MEMORANDUM

DATE: December 11, 2017
TO: Kari Parsons, PCD-Project Manager
FROM: Jeff Rice, PCD-Engineering
SUBJECT: VR-17-01 – Academy Village Filing No. 3
First Submittal

Final Plat

FINAL PLAT
ACADEMY VILLAGE FILING NO. 3

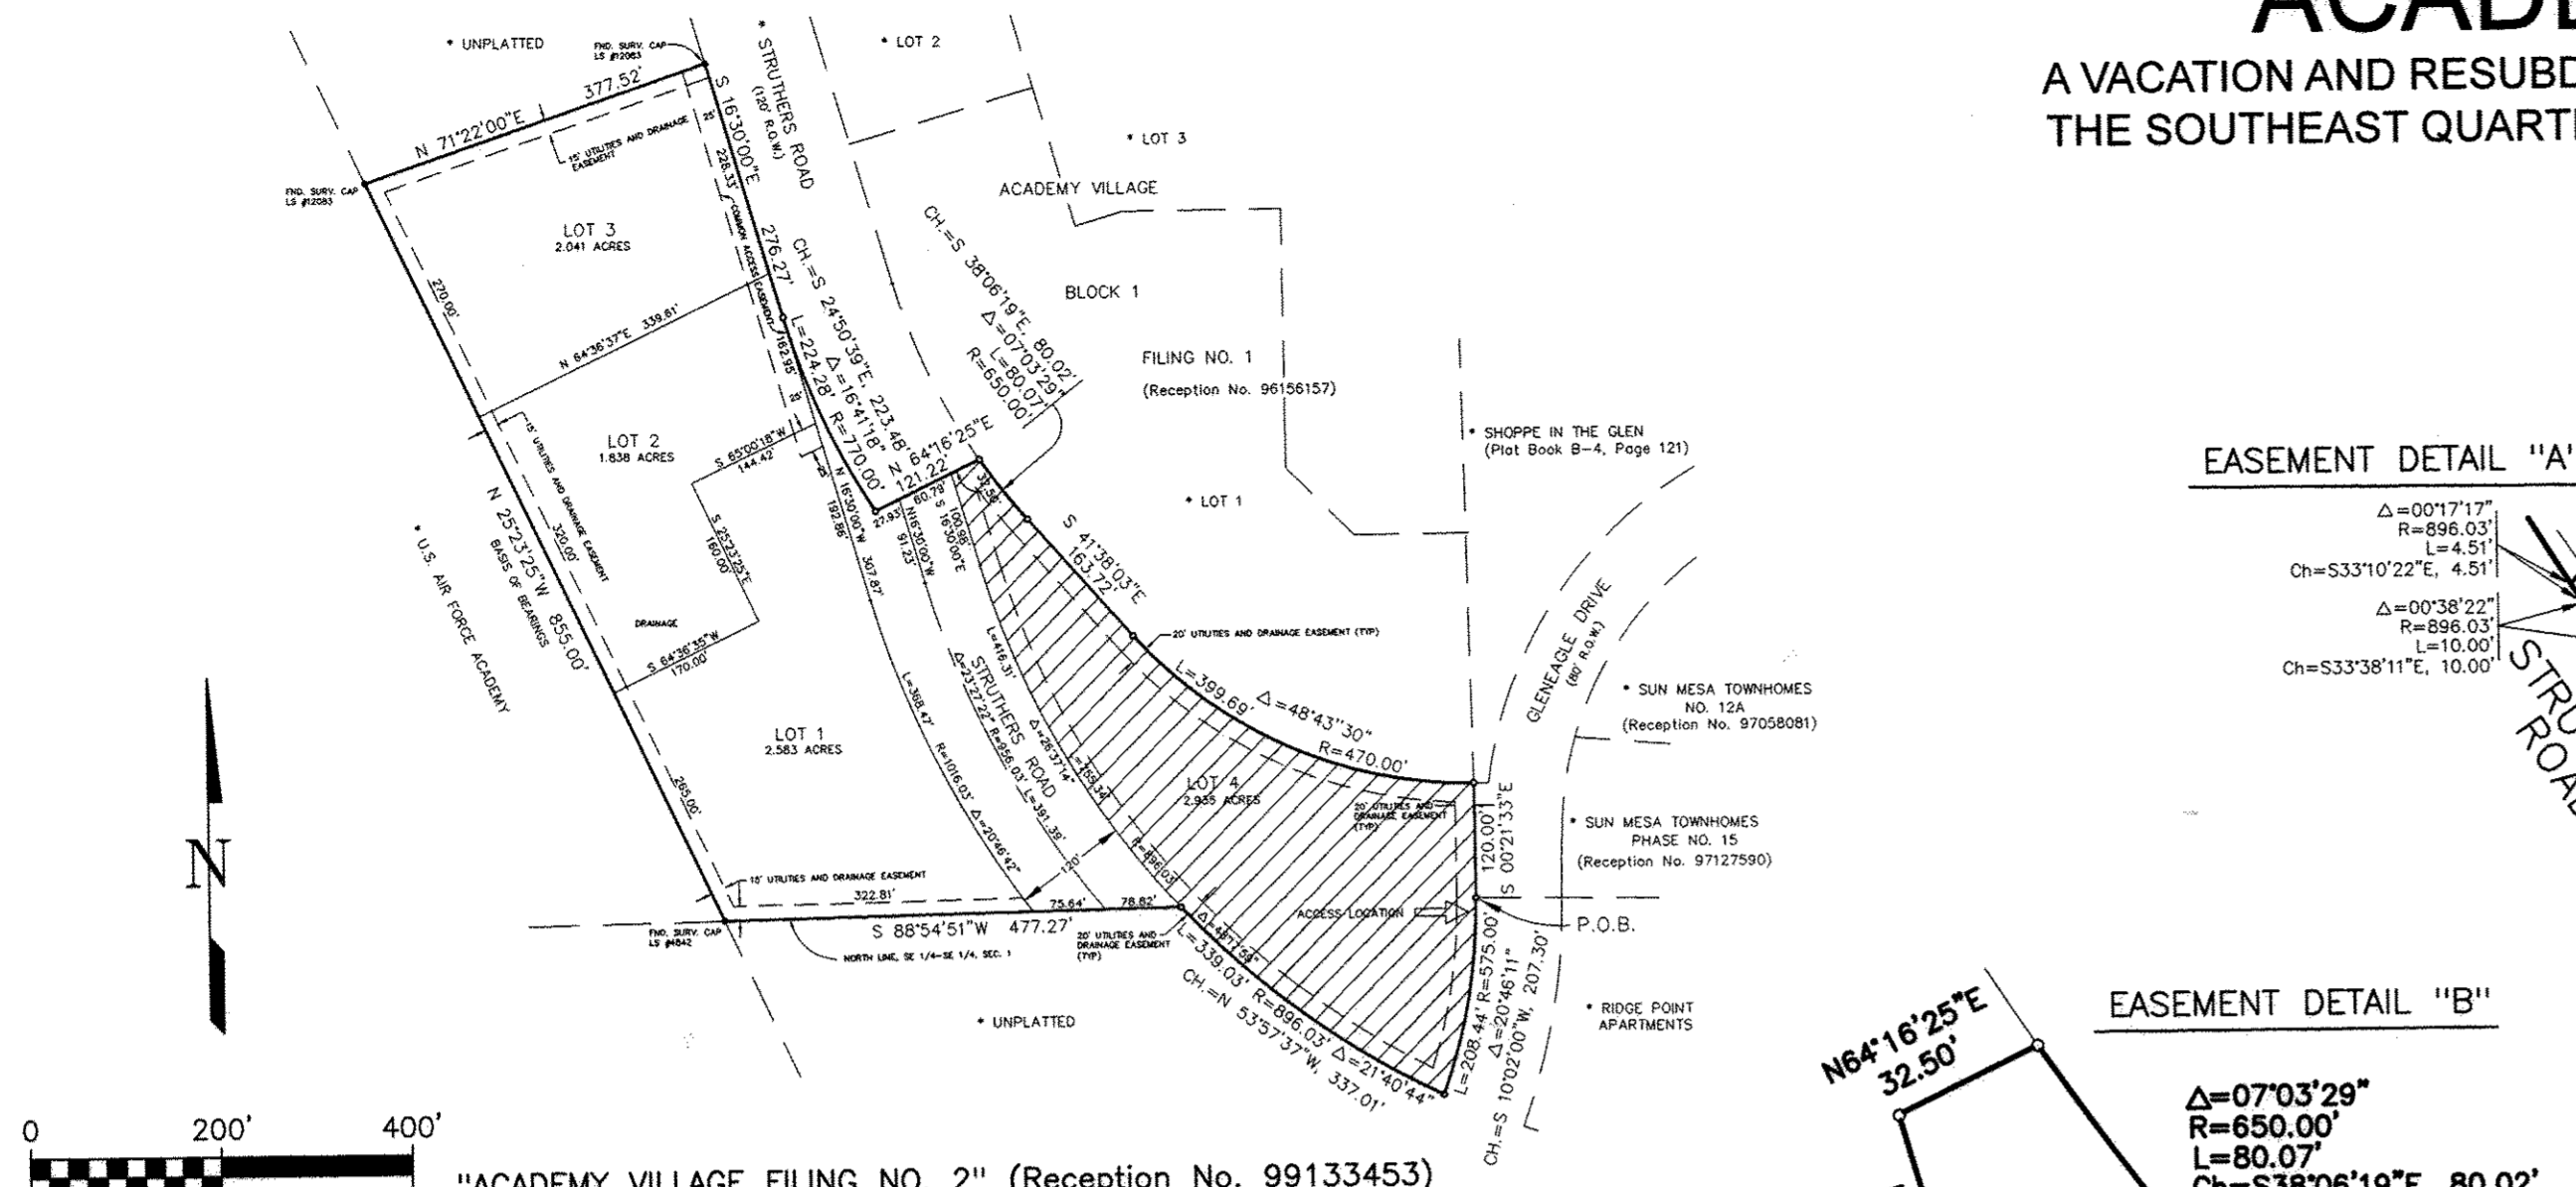
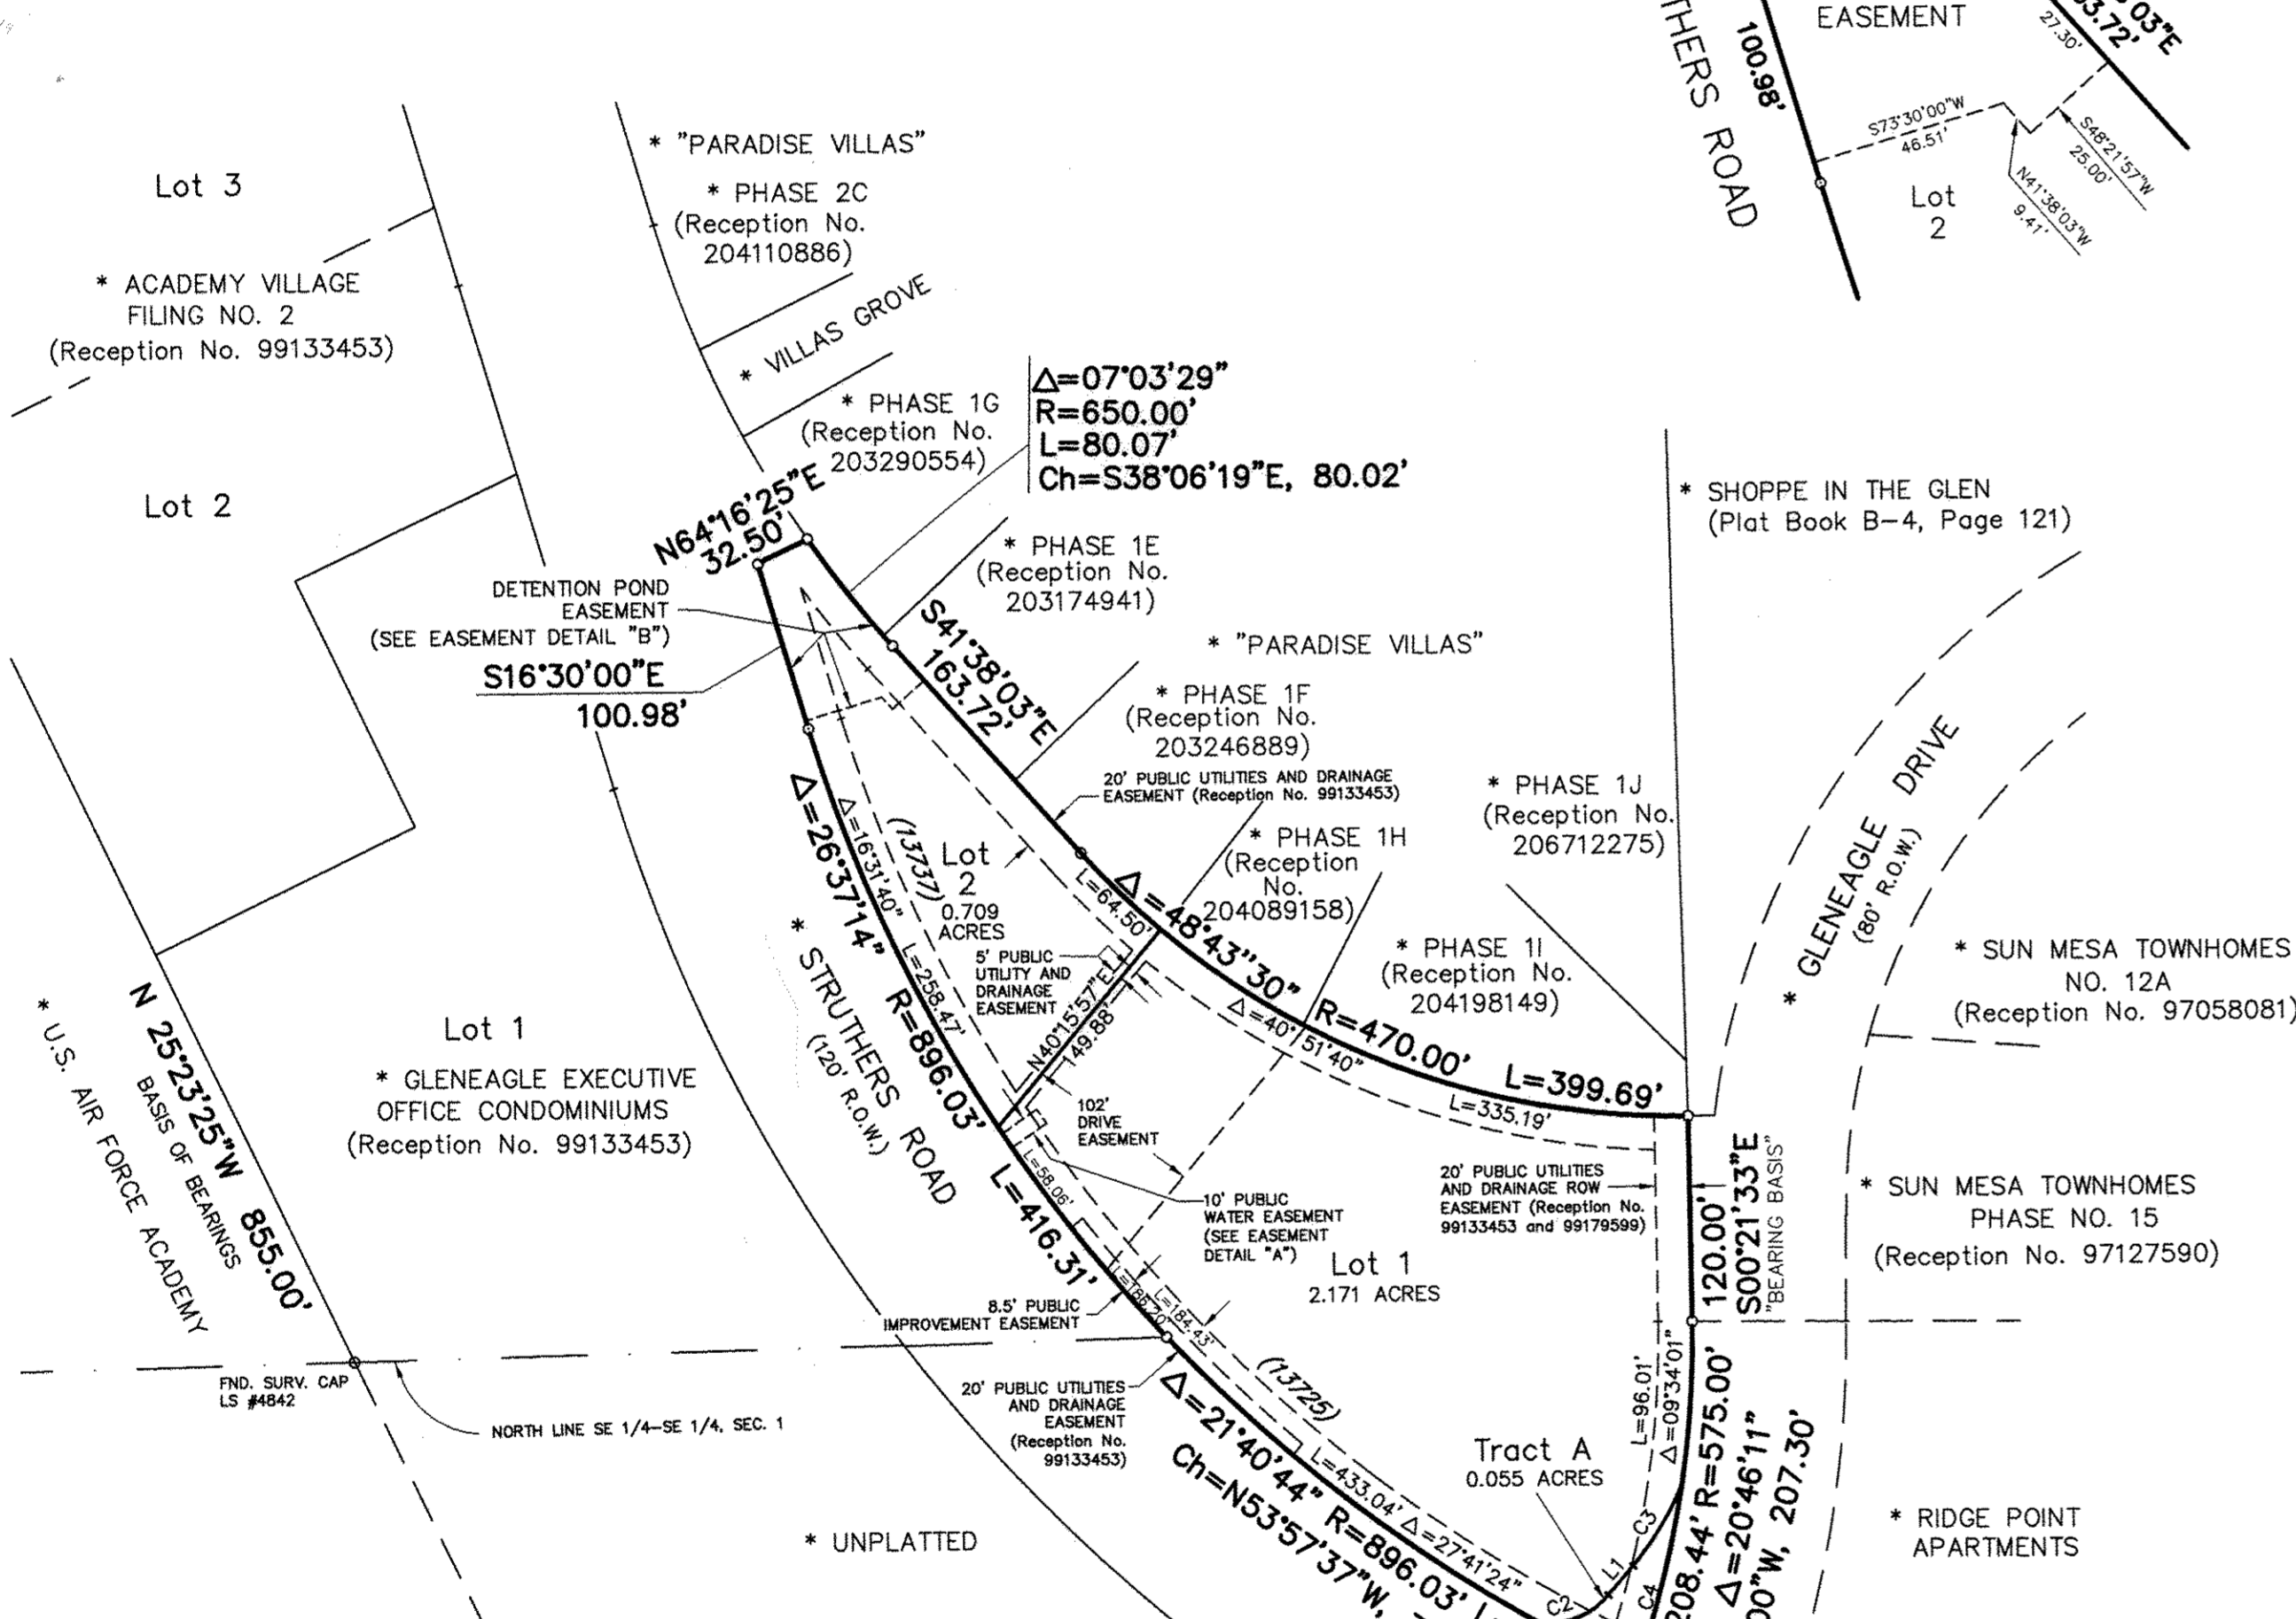
1. The 20-foot drainage easement along the public roads needs to be labeled "Public" if it includes the roadside ditch ... **Added - DVH**
2. Replace plat note #15 with the following: "The individual lot purchaser(s) shall be responsible for final design, construction, and maintenance of private detention pond/water quality BMP(s) as described in the approved drainage report for this subdivision. Final design, construction drawings and drainage report updates for the detention pond/water quality BMP(s) serving each lot shall be provided with Site Development Plan submittals. The detention pond/water quality BMP(s) shall be constructed and completed prior to the issuance of a certificate of occupancy ("CO") for the subject lots. The subdivision developer is responsible for providing financial assurances as indicated in the Subdivision Improvements Agreement and Financial Assurance Estimate for all detention ponds/water quality BMPs. All detention ponds/water quality BMPs shall be constructed prior to the release of said financial assurances. Individual lot purchasers shall enter into a Private Detention Basin / Stormwater Quality BMP Maintenance Agreement and Easement ("Agreement") prior to the issuance of any building permits for the subject lots. In the case that the developer constructs the detention pond(s), the developer shall enter into an Agreement for each pond constructed" ... **Replaced - DVH**

Multiple easements exist based on the title commitment. Identify and show reception numbers or book and page of easements per the title commitment. If some are to be vacated identify on the plat.

Is this a proposed lot line? Please thicken so it is clear and increase the distance and bearings to represent the legal description of the 2 lots being platted.

the Adjacent properties information is not accurate on this as platted map.

Identify the tract or easement on the plat

No tract is shown.

Public

PLATTED EASEMENTS ARE SHOWN "AS RESUBDIVIDED" AND ARE STILL IN EFFECT - DVH PLAT DRAWING.

MADE LINE THICKER AND CLARIFIED LOT DATA - DVH PLAT DRAWING.

THE PURPOSE OF THE "AS PLATTED"
 DATA IS TO SHOW WHAT IS "TO BE
 VACATED" FROM THE "ORIGINAL"
 RECORDED PLAT BACK IN 1999 ...
 CURRENT ADJACENT PROPERTY DATA
 SHOWN ON "AS RESUBDIVIDED" DATA - DVH

IDENTIFIED AND ADDED EASEMENT DETAIL
 ON PLAT DRAWING, SUBJECT TO
 EASEMENT AGREEMENT - DVH
 NOTE 18.

CHANGED TO WORD 'LOT' - DVH
 DEDICATION BLOCK.

LABELED - DVH
 PLAT DRAWING.
